Objection to Planning Application: R/64/17/PL Location: St Mary's Close, Hurst Road, Rustington, BN16 3AP

Re: Objection to Planning Application: R/64/17/PL

Location: St Mary's Close, Hurst Road, Rustington, BN16 3AP

Drg No: 151117_SS-01 Rev: D

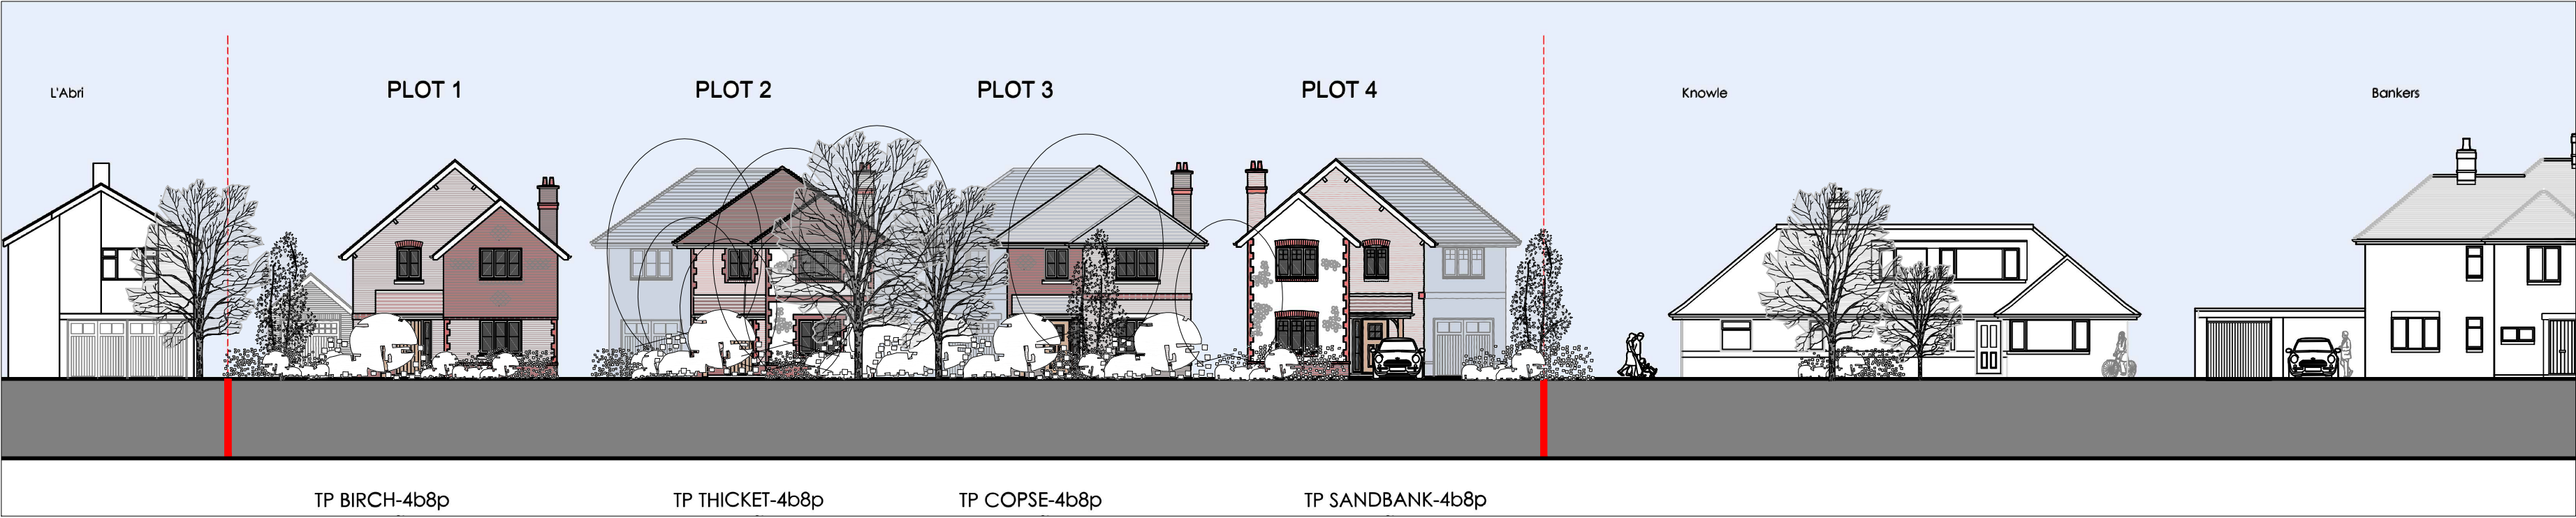
- 3) **Design & visual impact** – The proposals are for two slightly different designs and the developer has attempted to make them look different by using various cladding materials. However our objection is that as seen from the elevation plans this is just superficial, they still look very similar (MJH Street Scene Drawing). They do not fit with the individual properties in Hurst Road and the proposed development will spoil its appearance and character. In fact the proposed scheme contravenes the Local Plan - D SP1 Design as it does *not* “*Respect, improve and enhance the existing surrounding environment*”.
